CITY OF PORTLAND, MAINE

PLANNING BOARD

May 1, 2018

Project Name: 25 Monument Condominiums
Address: 25 Monument Street
Applicant: Monument Partners, LLC
Planner: Matthew Grooms

Drawing file: 1. Original Plans / Plan 7. Portland25MonumentAutoTurn.pdf

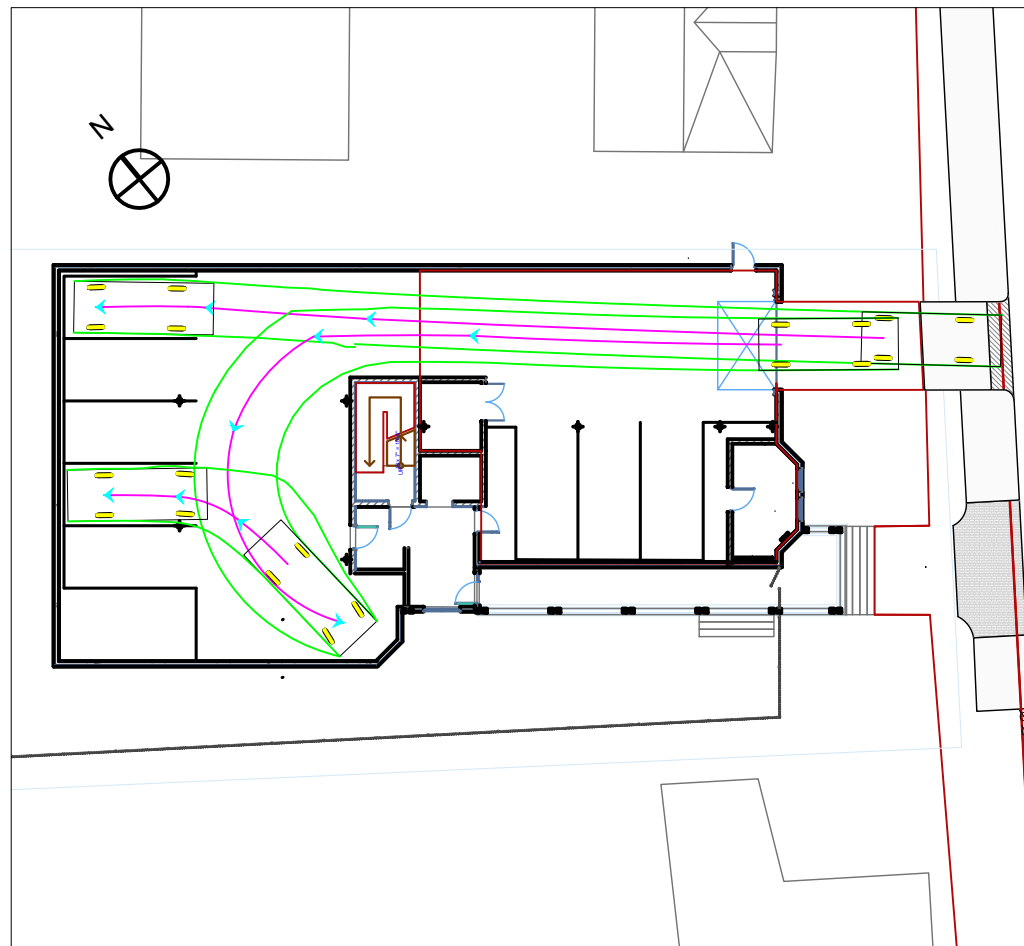
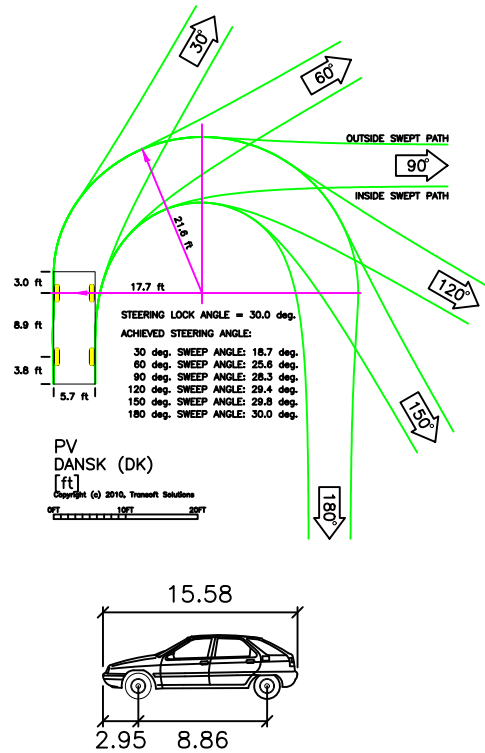
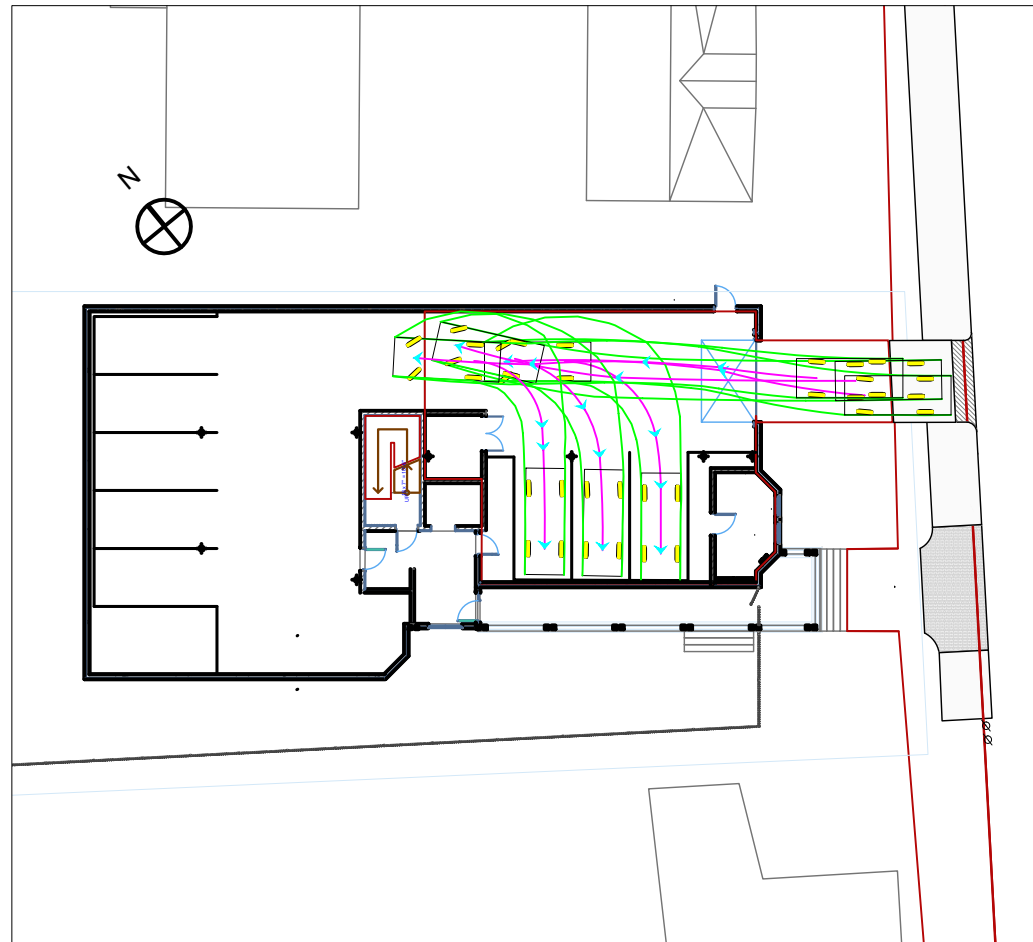
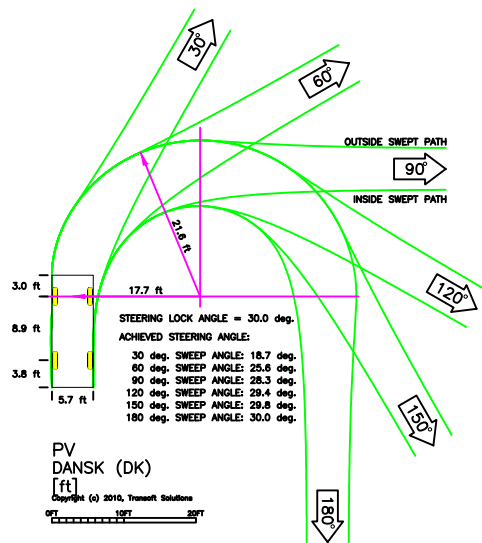
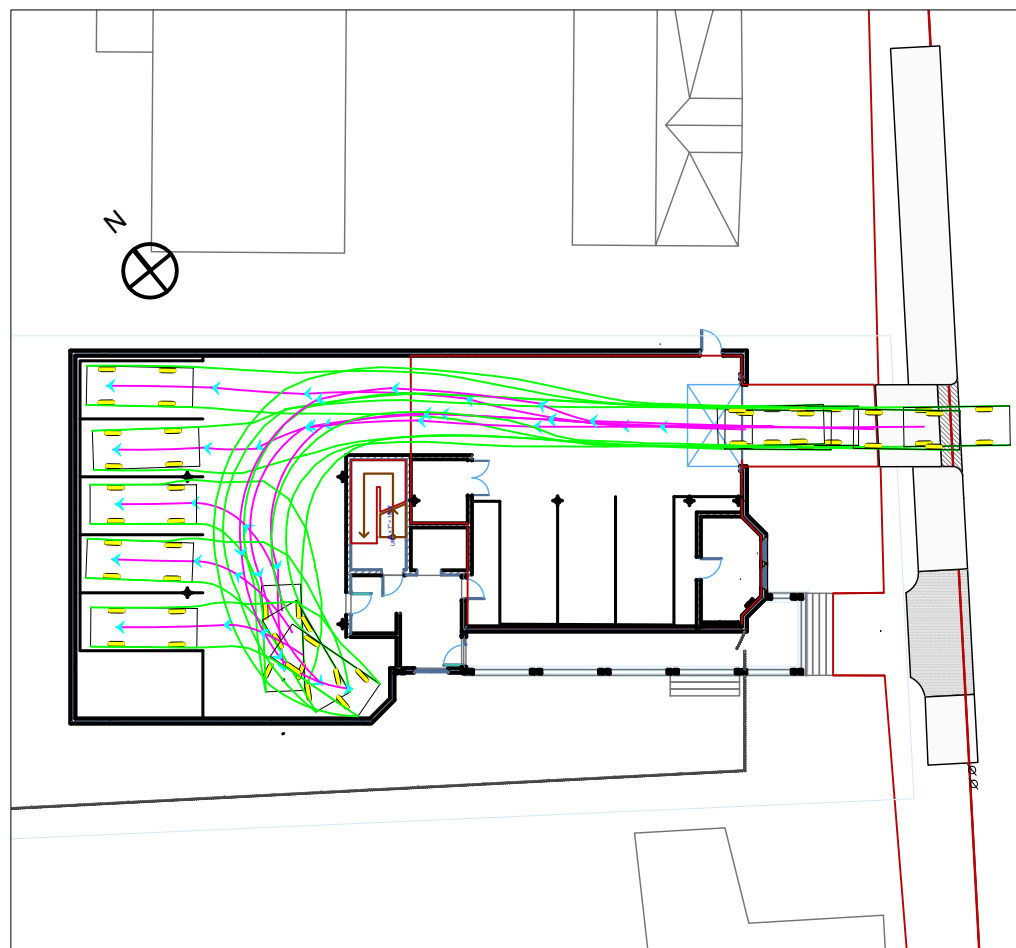
- The applicant has provided a vehicle turn analysis that indicates vehicle circulation is feasible. I continue to review this information, but my initial review supports their conclusion that reasonable circulation can be provided. I would note that the building columns will present vehicle turn challenges.

Status: The applicant has provided the requested analysis. The analysis indicates reasonable circulation is provided and I have no further comment.
